MEMORANDUM

SUBJECT: SF-21-032– Sterling Ranch Filing No. 3
Second Submittal

Engineering Division

GRADING AND EROSION CONTROL PLAN

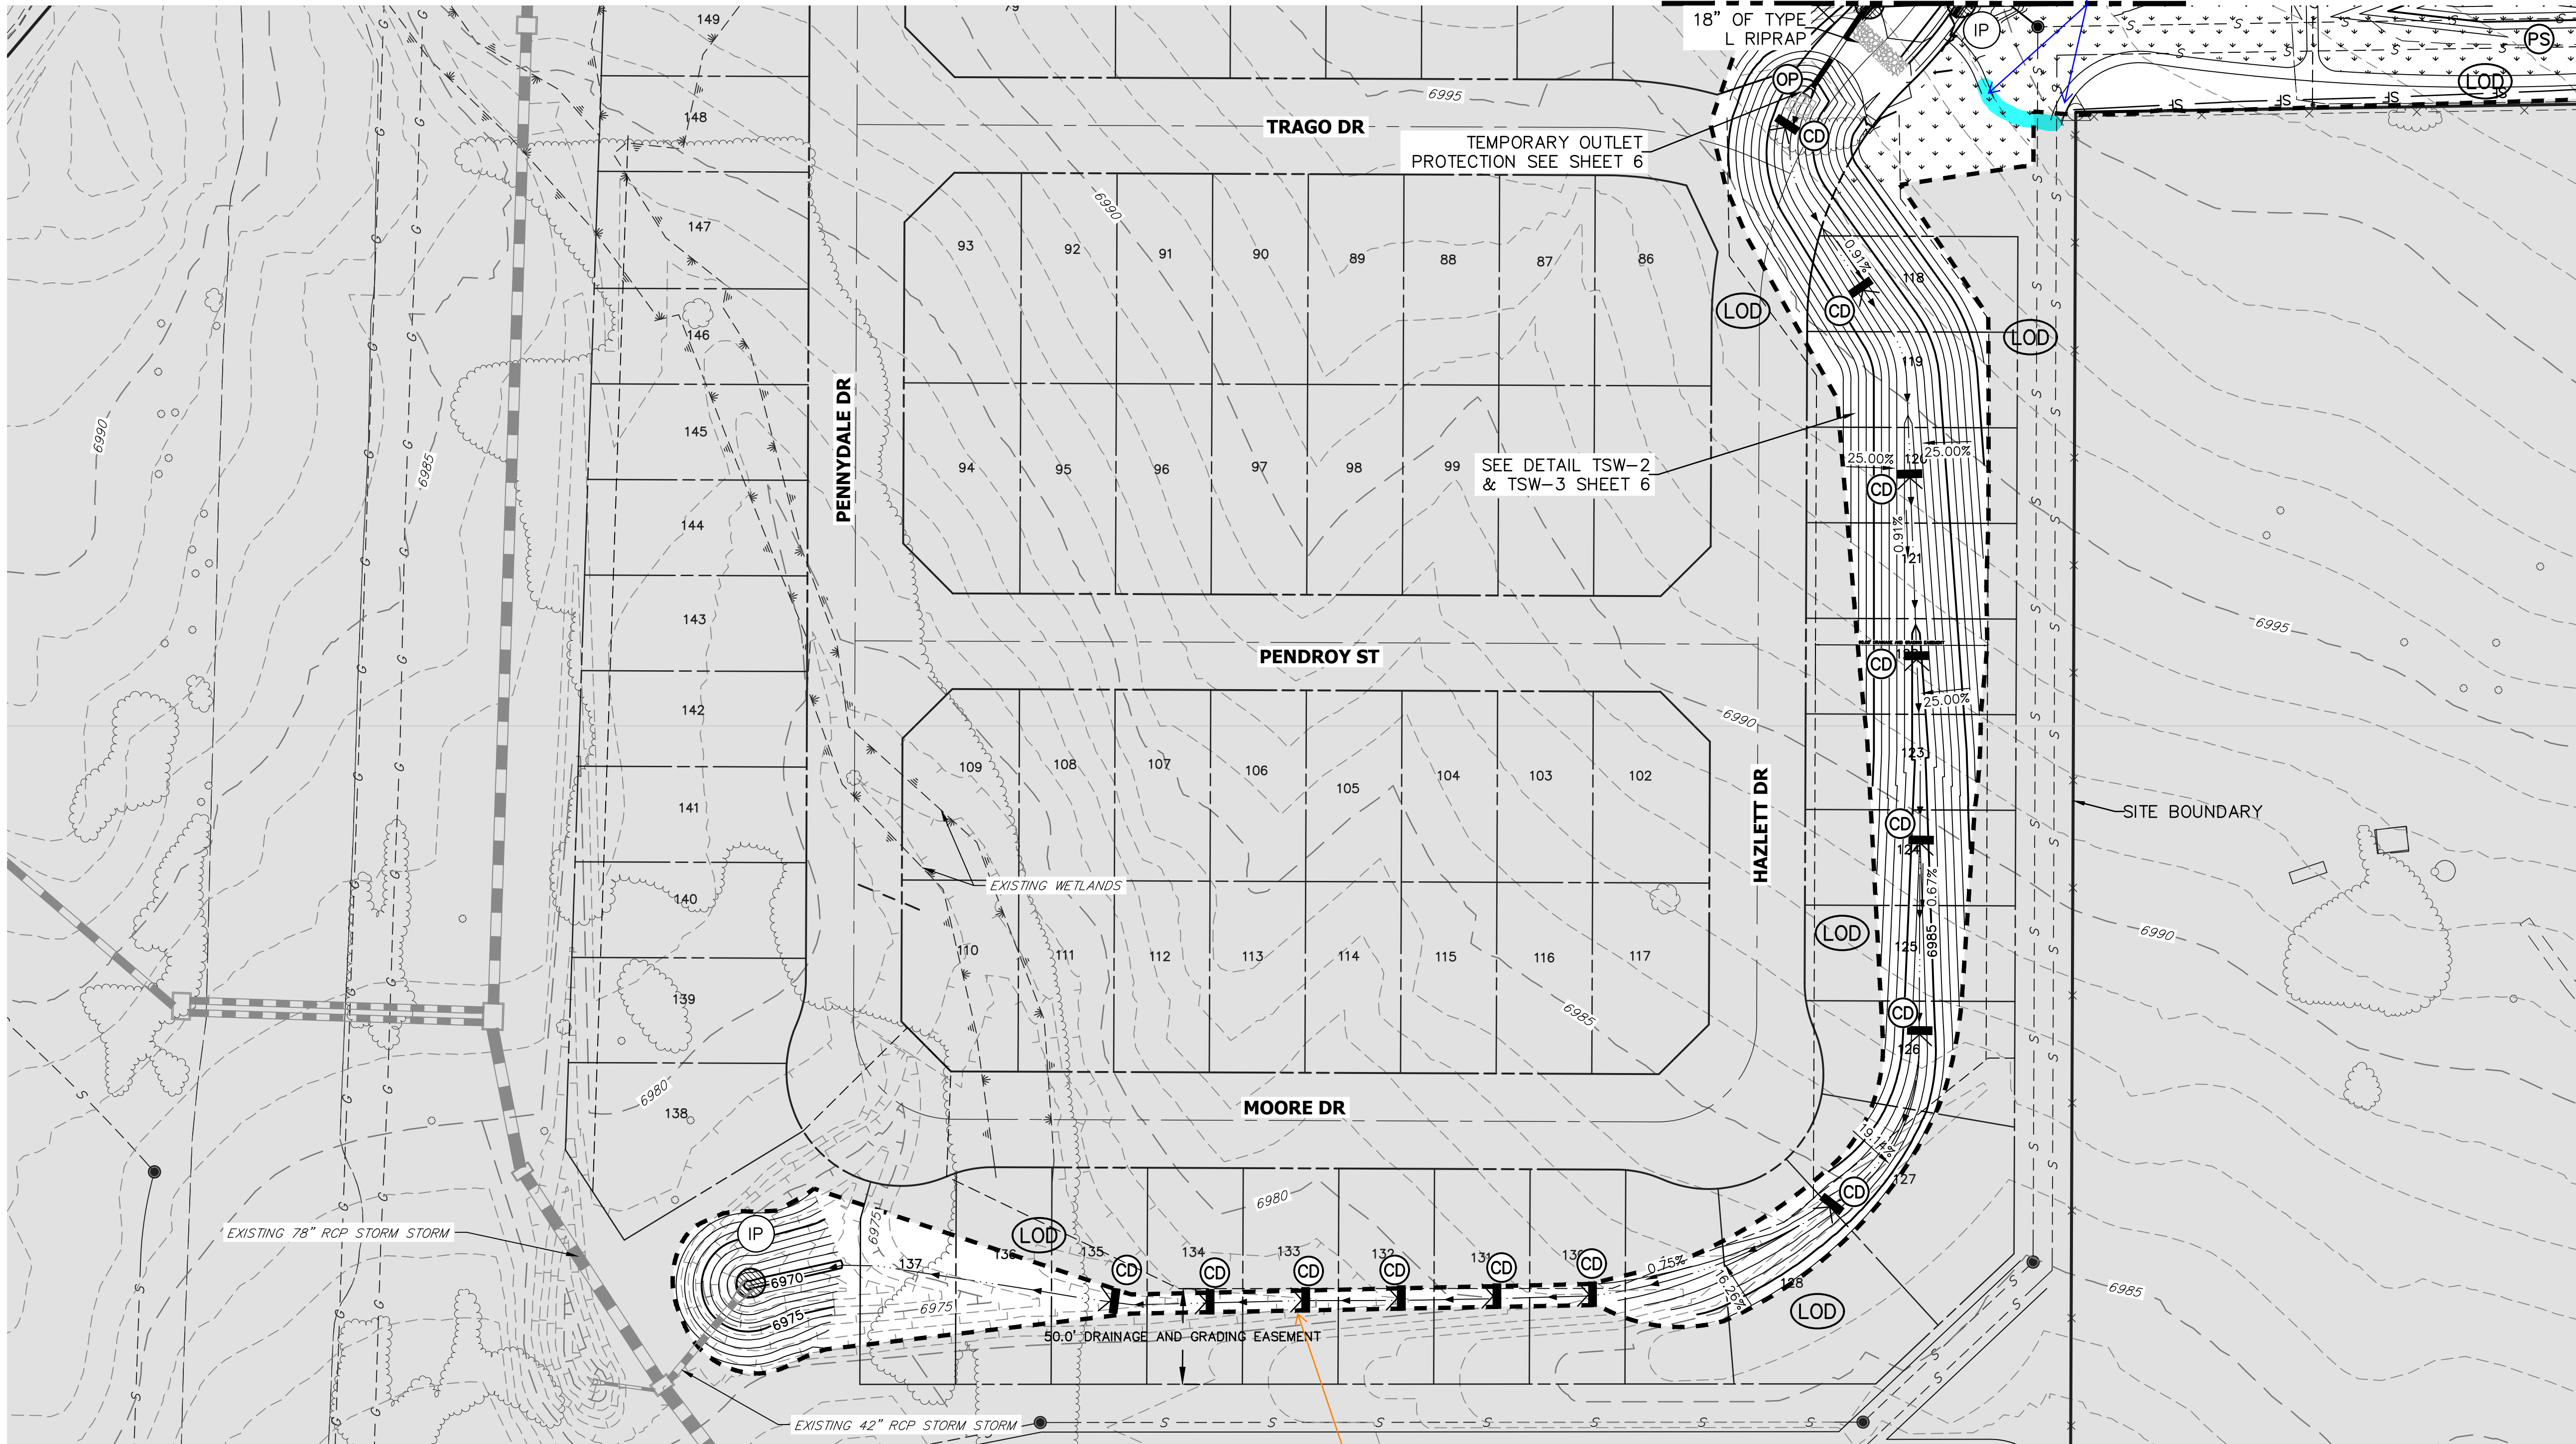
1. **Through 3 – Resolved.**
4. Geotechnical issues:
 - a. **Resolved.**
 - b. **Resolved.**
 - c. Note: a pavement design will be required once roads have been rough graded.
5. **Resolved.**
6. **Resolved.**
7. Provide cross-sections for the trails/maintenance access roads along Sand Creek.
8. **Resolved.**
See CD and GEC Plan redlines. **Partially resolved; see updated/remaining CD redlines. JR Response: Addressed**
